REQUEST

Approximately 23.37 acres located north of Neal Road, east of Catalyst Boulevard, and south of IBM Drive.

The petition proposes a residential community of up to 73 multi-family attached (townhome) dwelling units and up to 324 multi-family stacked dwelling units on vacant land. The petition contains an affordability component.

**STAFF
RECOMMENDATION**

RZ-1.0

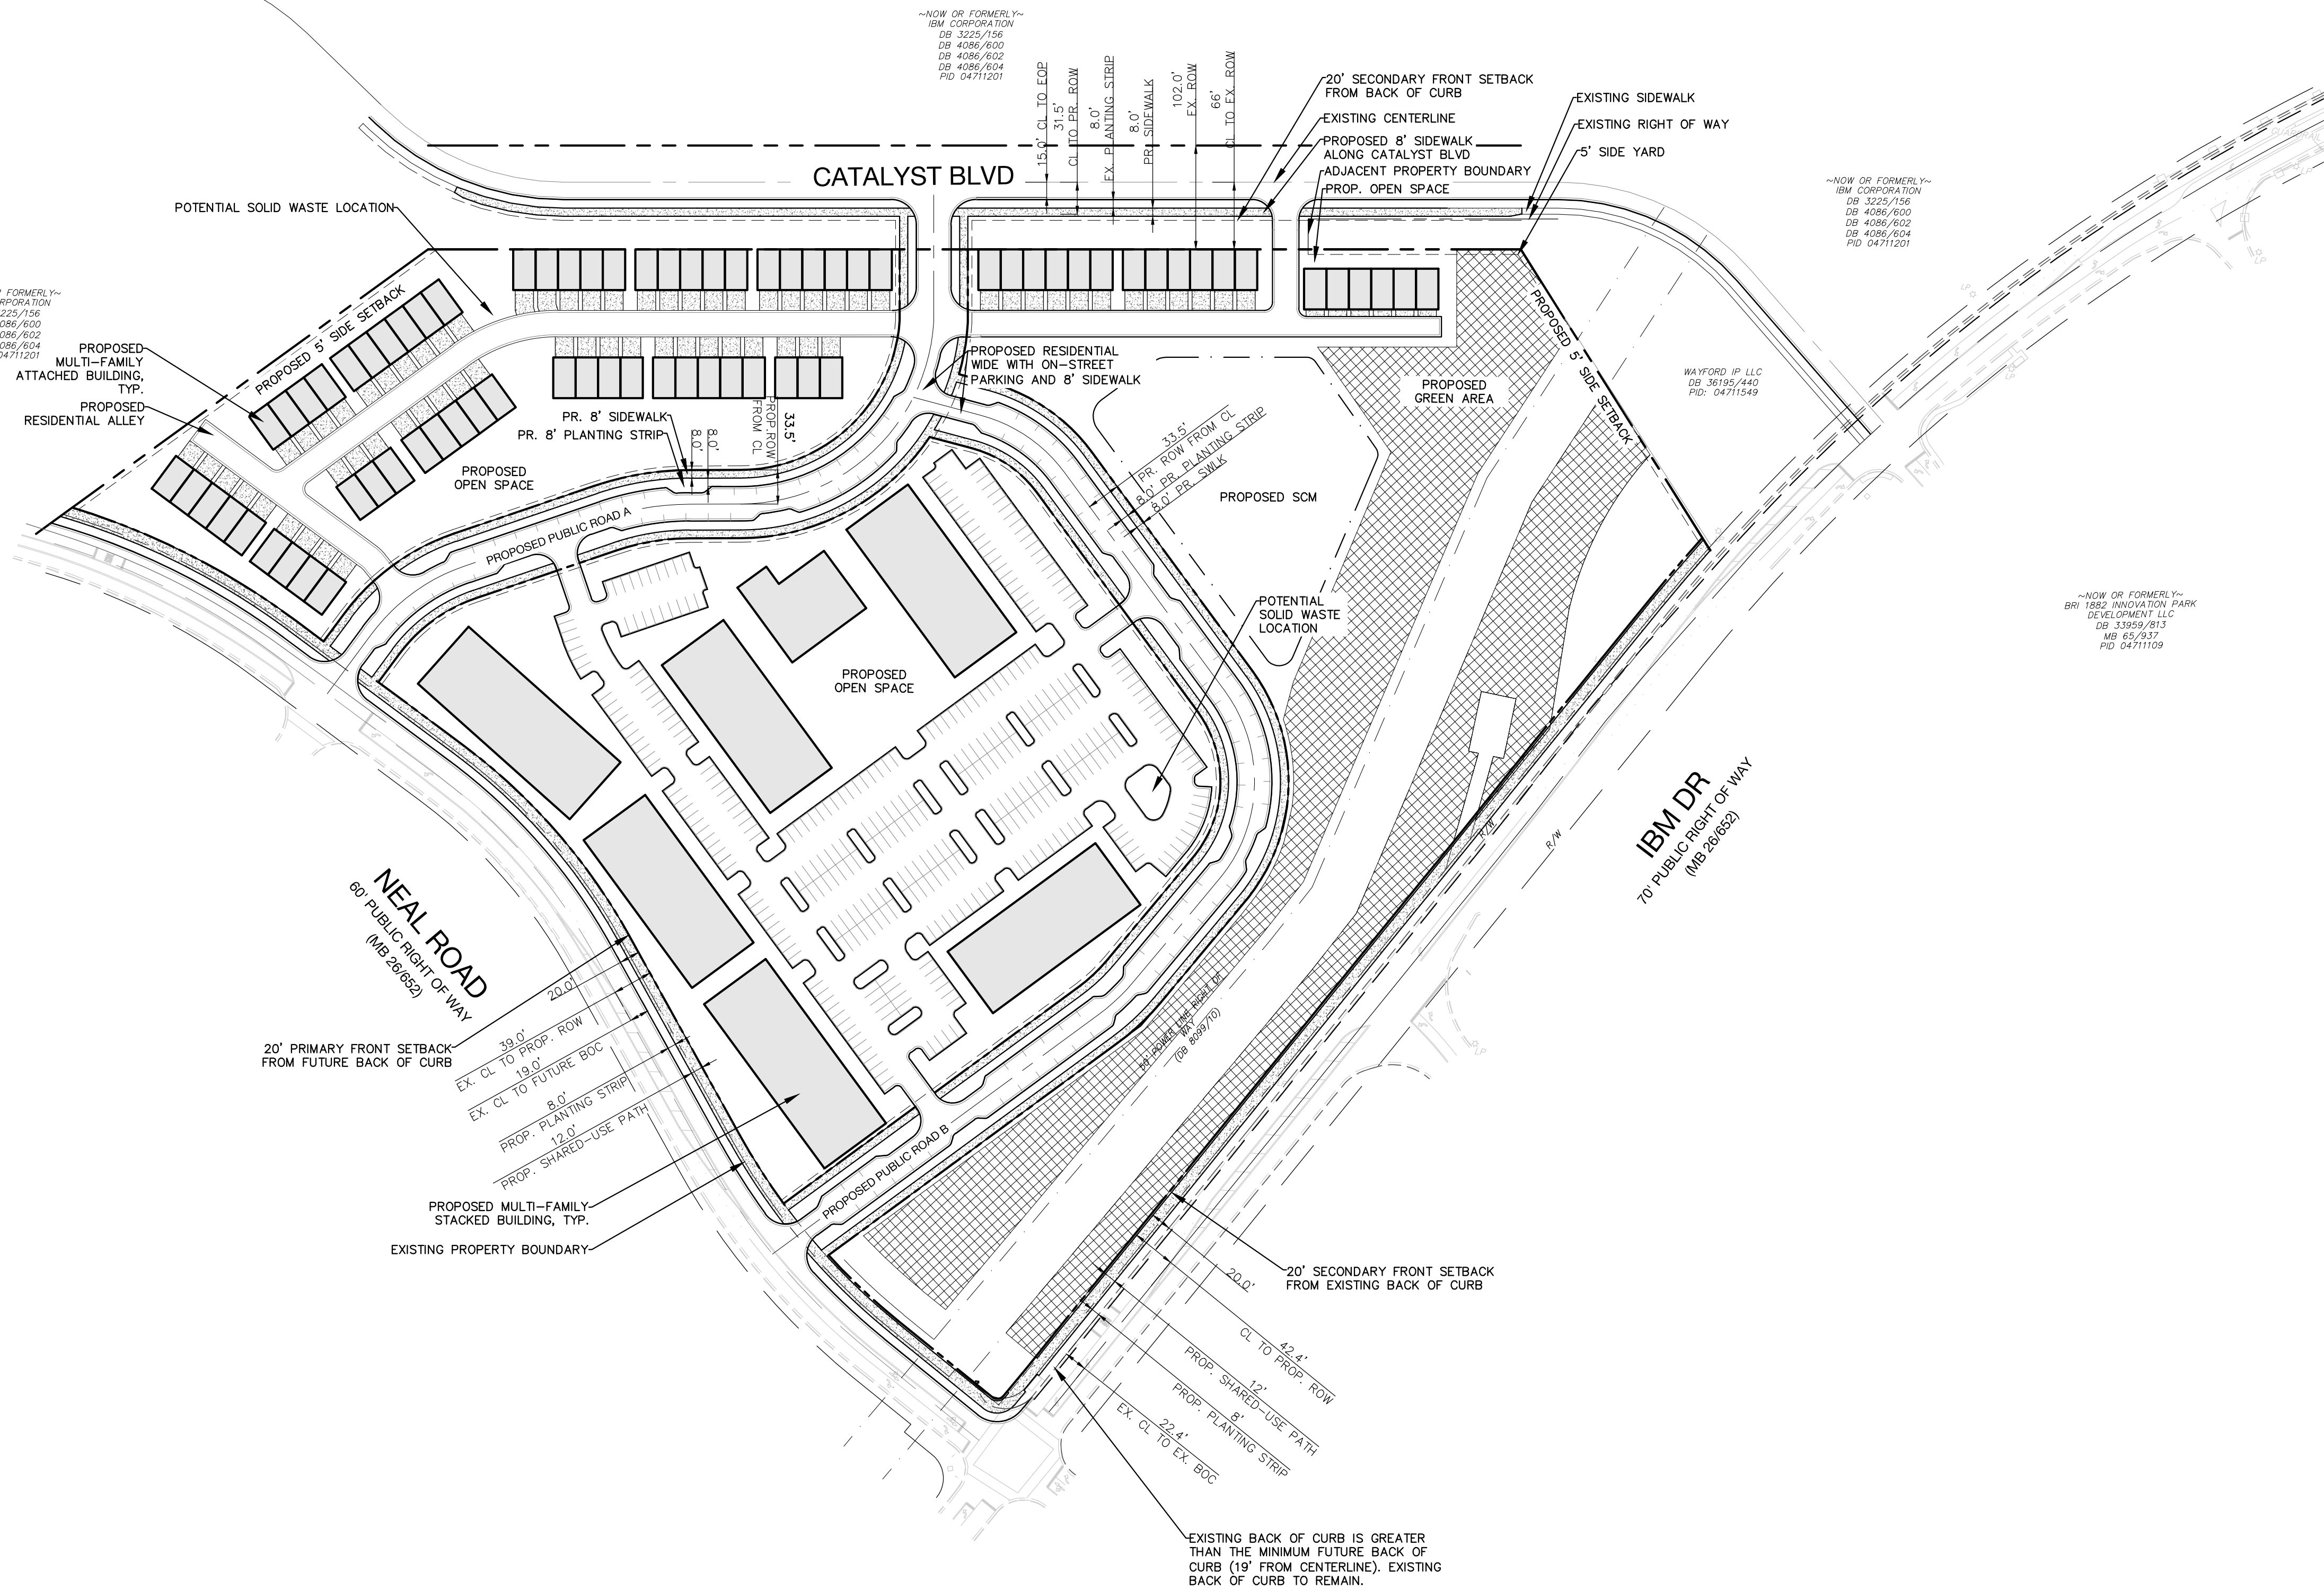
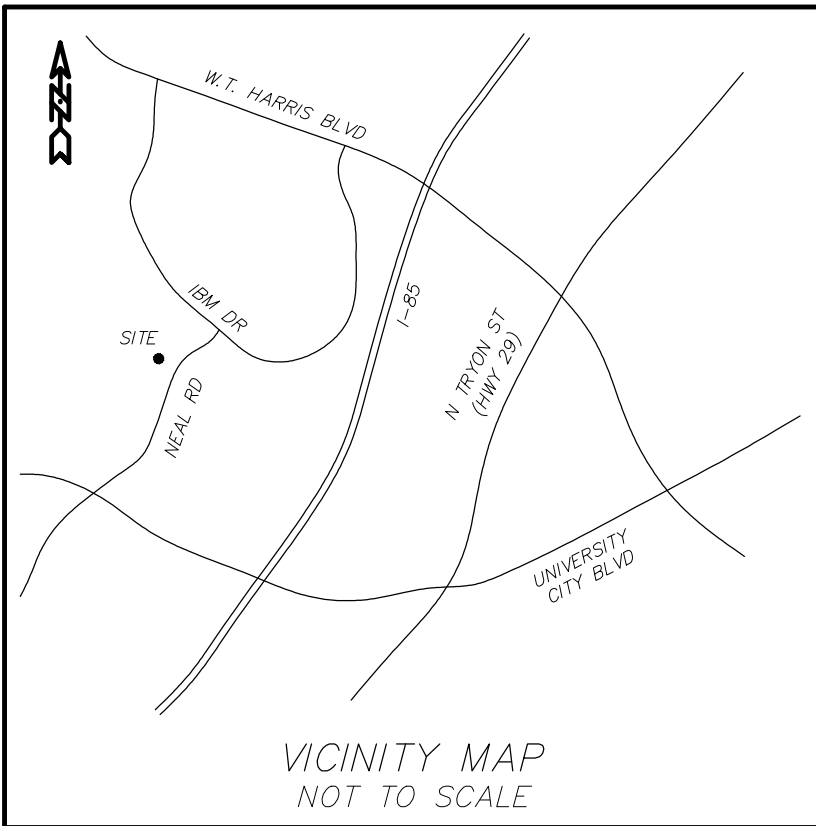
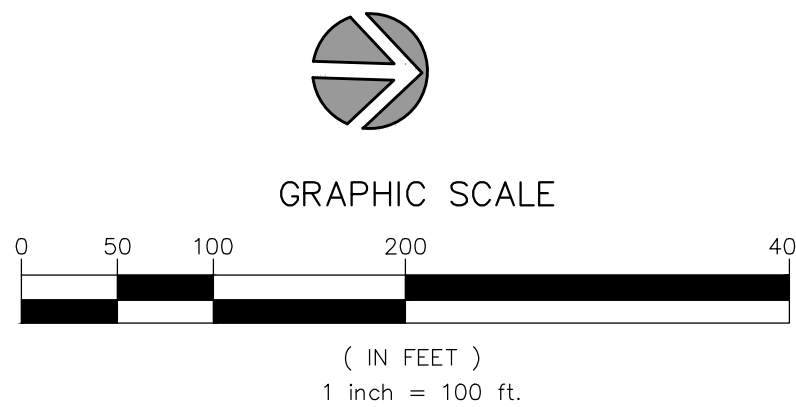
1. ~~Label and dimension the curb and gutter from the centerline for each road on the site plan.~~ Addressed
2. ~~Add conditional note to provide a minimum of 50 feet of ROW from the centerline of IBM Drive to accommodate the future right turn lane. Some of the ROW can be placed in an SUE. This ROW will allow for a right turn lane to be constructed at the signal which will drastically increase the functionality of the intersection.~~ Rescinded

3. ~~Provide greater proportionality in the attached multi-family building forms by decreasing multi-family stacked units and incorporating a mixture of building types.~~ Rescinded
4. ~~Provide prescriptive standards for each open space element that will be utilized.~~ Addressed
5. ~~Consider adding a limit to the number of 6-unit buildings.~~ Addressed
6. ~~Provide a minimum dimension for stoops.~~ Addressed
